**Pacific Brook Christian School, Muswellbrook (SSD-16858710)
Response to Submissions**

ATTACHMENT 1

Note: This map presents the maximum difference in flood levels between the proposed and existing development scenarios. This scenario assumes the proposed MC2 (Golf Course Bund) was implemented. In the 100yr ARI / 1% AEP no flood impact is calculated.

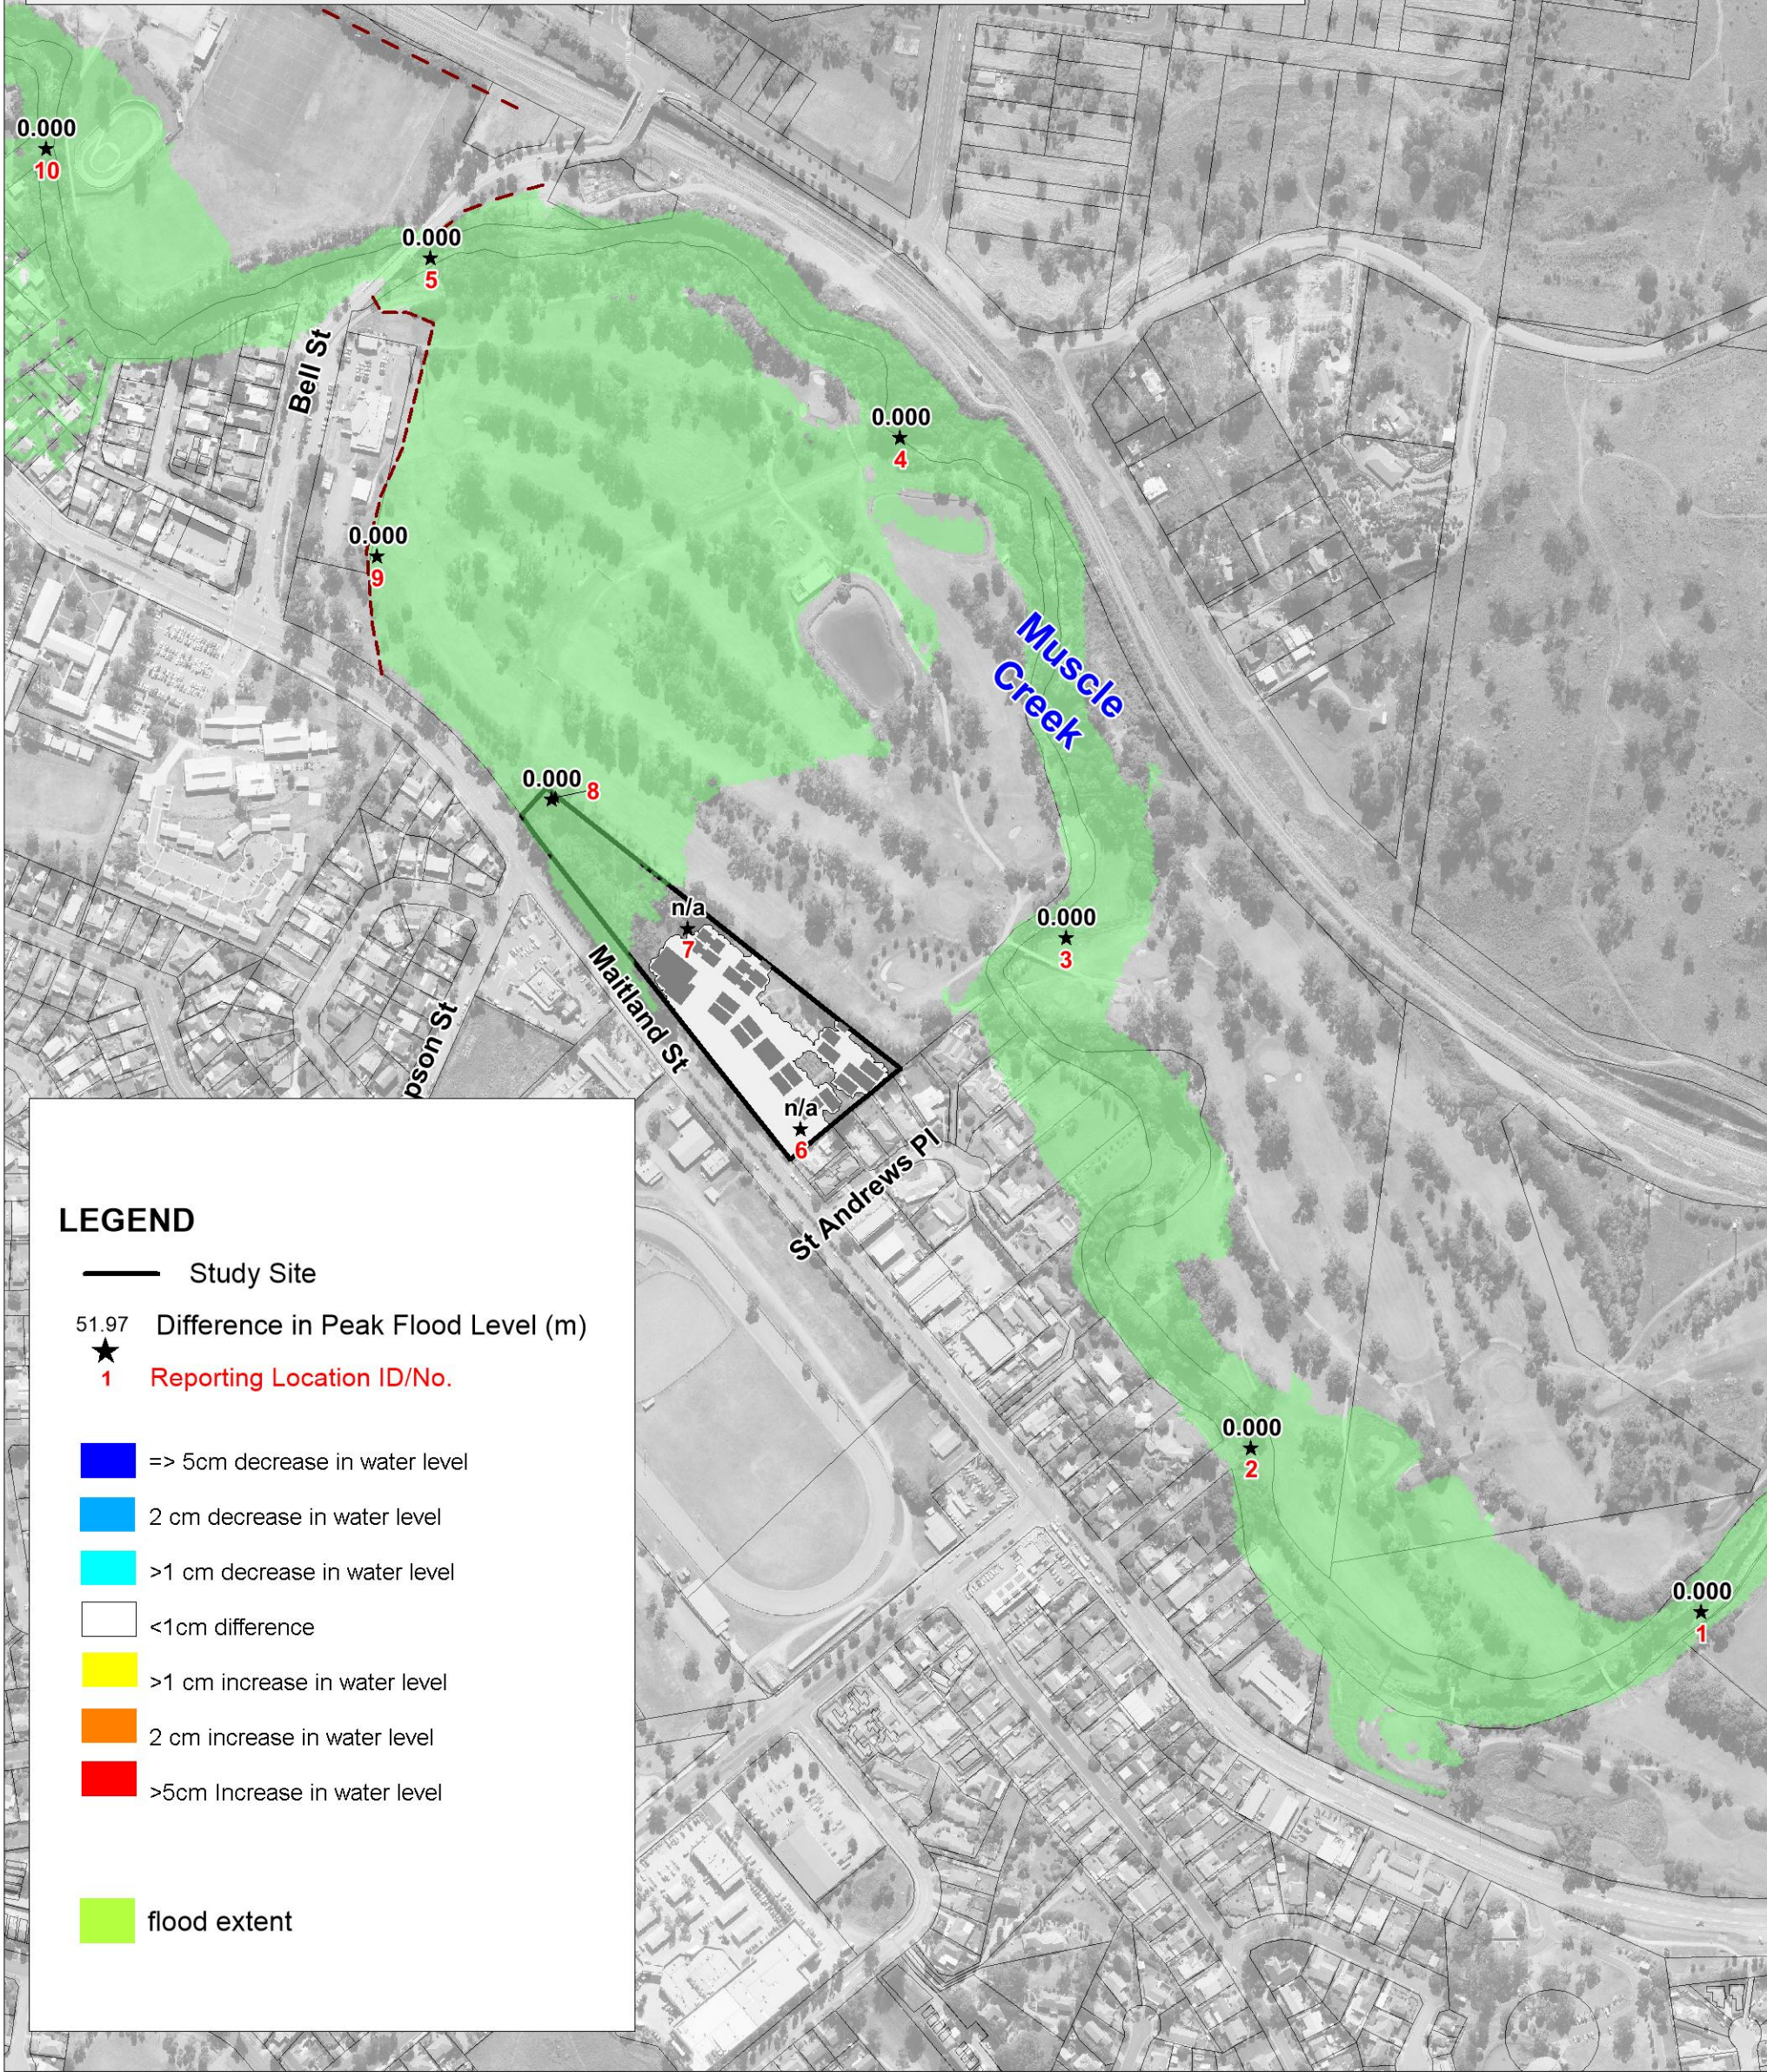
- Biodiversity and Conservation Division (BCD) have reviewed the proposal and raised substantial concerns with regard to flooding within the site. The Department shares the concerns of the BCD and requests that you amended your flooding report and respond to the comments raised by BCD.
- Additionally, the potential effects of climate change, sea level rise and an increase in rainfall intensity has not been adequately assessed. Please provide a more comprehensive flood assessment which addressed these impacts.
